CROSSROADS NORTH

PRELIMINARY PLAN / LANDSCAPE STANDARDS

Preliminary Plan Drawings_v3-redlines.pdf Markup Summary 11-2-2022

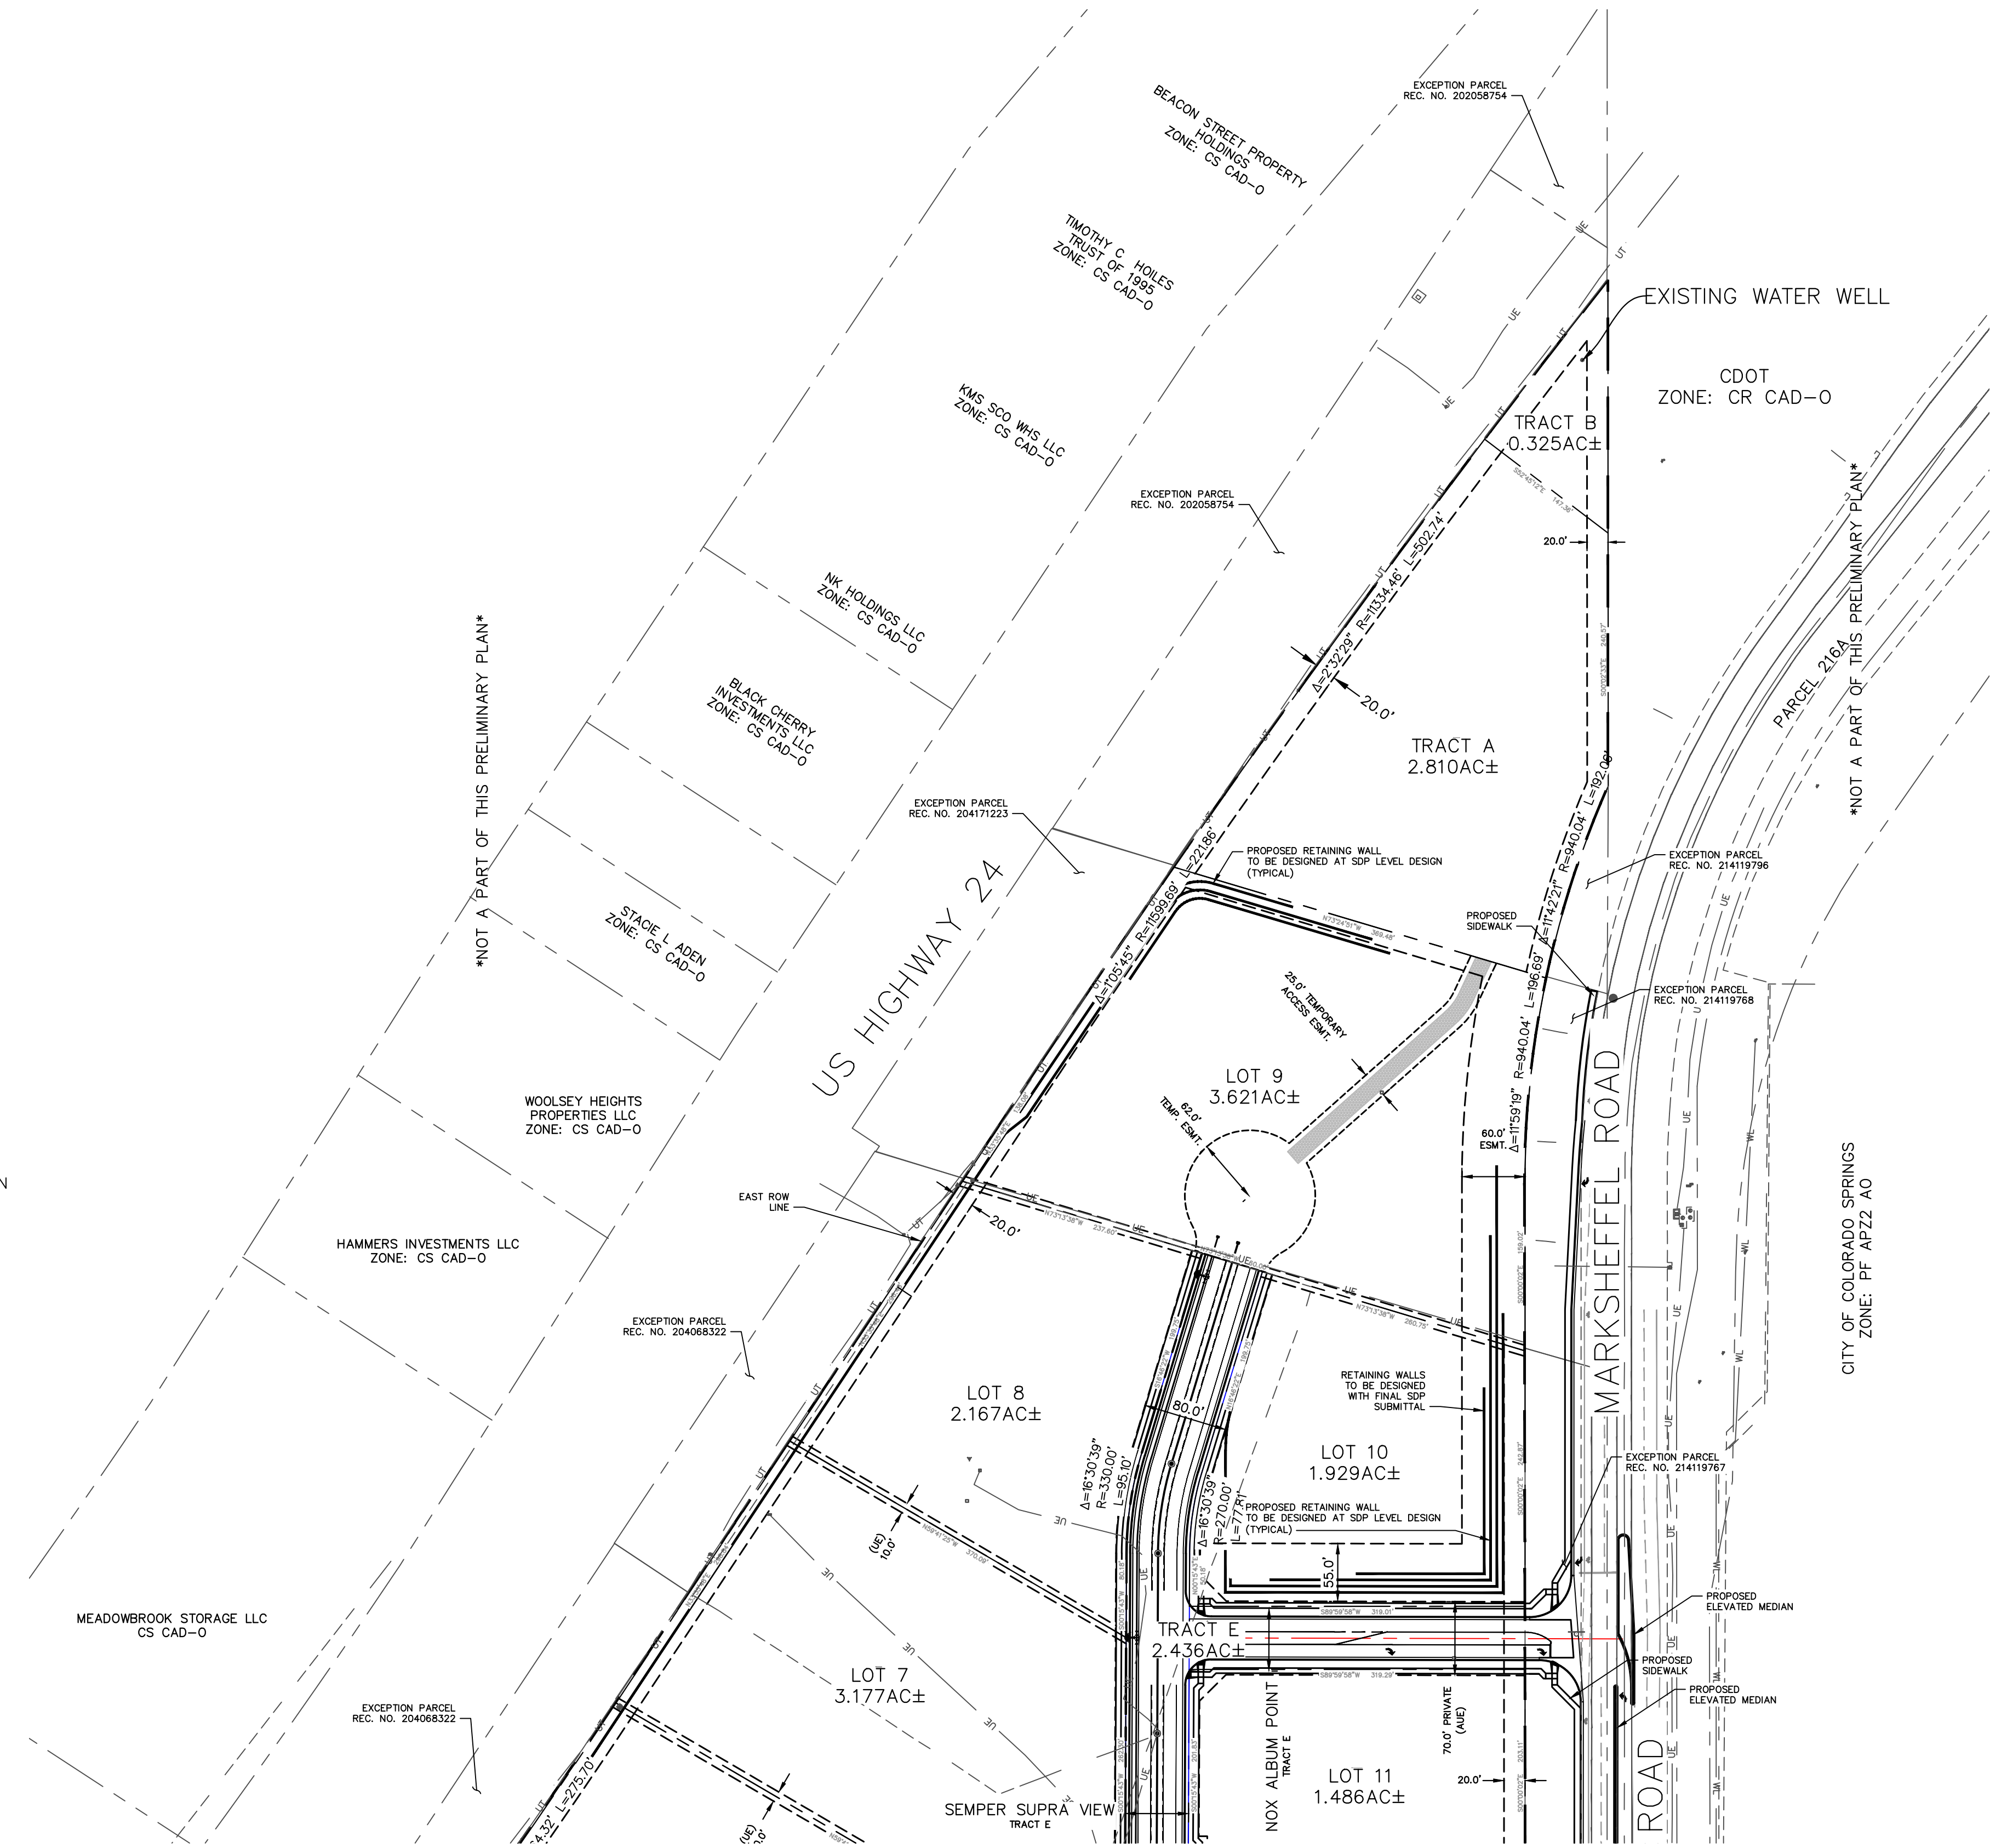
Review #1: Include a preliminary grading plan showing proposed contours. Include slope tags along the road centerline.

Review #2: Staff recommends placing the existing and proposed grading within additional sheets titled preliminary grading plan. Having everything combined within the preliminary plan sheets is making the sheet too busy to clearly show all the information. Additionally, per the Review #1 comments include slope tags along the centerline of the road.

Similar comment applies for the utilities (Wtr, San). Staff recommends placing these in a separate preliminary utility plan. On the separate utility plan turn off the striping layer. Its difficult to differentiate between Water, Sanitary and the lane striping. See the snippet to the left for an example which shows lane striping water line, sewer line and C&G.

Unresolved. Review #3: For legibility, add a separate Preliminary Grading Plan to show proposed grading and turn off the contours on sheets 2 & 3. Add a separate Utility Plan sheet showing the utility layout and turn off the wtr/sewer/storm on sheets 2 & 3.

Label the dashed line and the hatch.

At a minimum label the proposed and existing major contour line elevation.

Show & label the drainage easement for the channel within Lots 5 & 6.

Label what these two arrows means or provide a legend identify all symbols and line types used.

Label cul-de-sac bulb radius.

Label easement. Is this the temporary cul-de-sac easement in note #1?

label proposed sidewalk

Per the TIS the 2040 analysis identifies the need for 6 lane widening of Marksheffel Road. Additional ROW will be required along the Marksheffel Road corridor. Per County Criteria a 6-In principal arterial consist of a 210' ROW. It appears the ROW is approximately 90' for the road centerline. As such 15' additional ROW would be required along the frontage. Update the plan to show the additional ROW dedication.

Unresolved. Marksheffel Road has been deeded to the City of Colorado Springs. Coordinate with the City on any ROW dedication or preservation they may require along Marksheffel Road.

Coordinate with the City regarding lane configuration on Marksheffel Road.

PRELIM PLAN 2
SHEET 03 OF 14

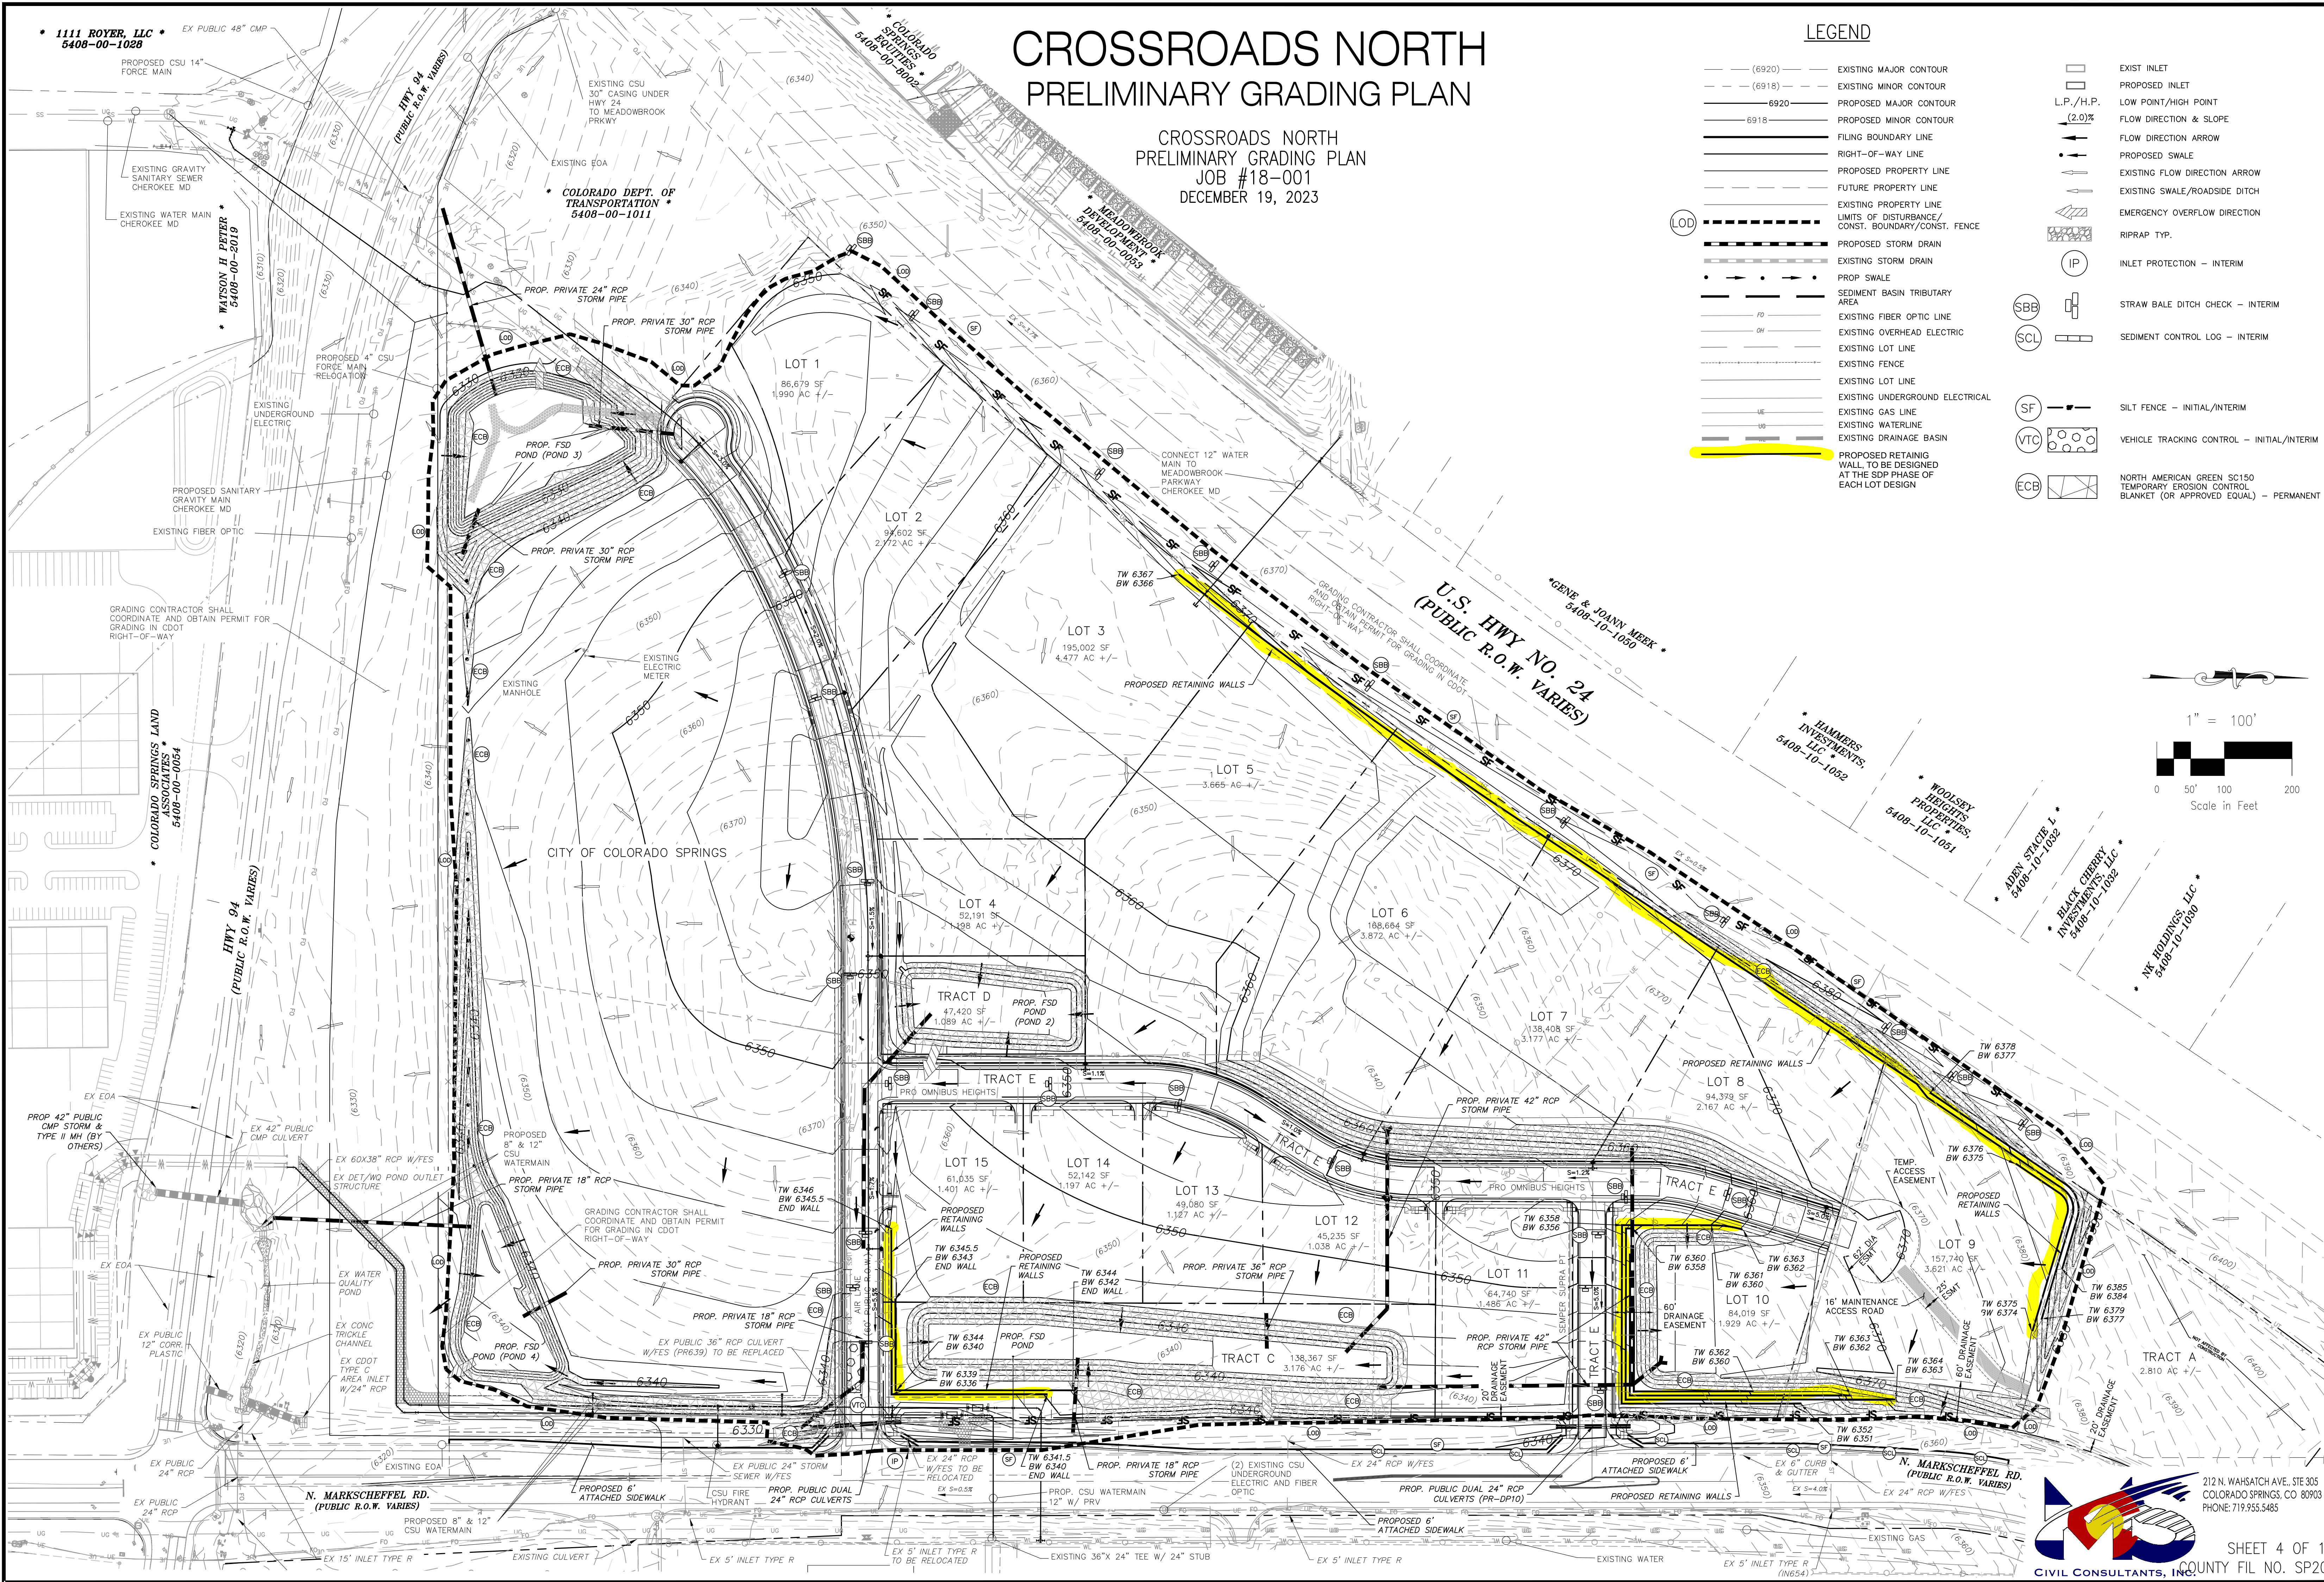
Review #1: Include a preliminary grading plan showing proposed contours. Include slope tags along the road centerline.

Review #2: Staff recommends placing the existing and proposed grading within additional sheets titled preliminary grading plan. Having everything combined within the preliminary plan sheets is making the sheet too busy to clearly show all the information. Additionally, per the Review #1 comments include slope tags along the centerline of the road.

Similar comment applies for the utilities (Wtr, San). Staff recommends placing these in a separate preliminary utility plan. On the separate utility plan turn off the striping layer. Its difficult to differentiate between Water, Sanitary and the lane striping. See the snippet to the left for an example which shows lane striping water line, sewer line and C&G.

Review #3: Label contours and include slope tags along the road centerline on the preliminary grading plan

label or remove these thick dashed lines.

show/label the access easement through Lot 7 for the pond maintenance road.
 Unresolved.

Review #1: Show the proposed roadway configuration of Air Lane and the intersection. Label the curb return radius. See Table 2-31 for minimum curb return radius.

Review #2: Unresolved. Label the curb return radius.

Provide a larger detailed preliminary grading at the intersection. There appears to be drainage issues with two existing culverts, proposed sidewalk and existing roadside ditch.

Adjust intersection spacing to meet criteria or remove on the intersections. Staff recommends removing the eastern intersection (#9) and converting this to a cul-de-sac.

Spacing should be sufficient to also meet the required auxiliary left and/or right turn deceleration lane lengths.

Coordinate with the traffic engineer for auxiliary lane requirements at these two intersections. Based on peak hour vph separate turn lanes are required at intersections 6 through 9. Example both intersections on Air Lane require a WBRT lane.

Update the cul-de-sac bulb radius to match the County detail SD_2-75.

Unresolved. Label cul-de-sac bulb radiues.

Adjust ROW so cul-de-sac is within the ROW.
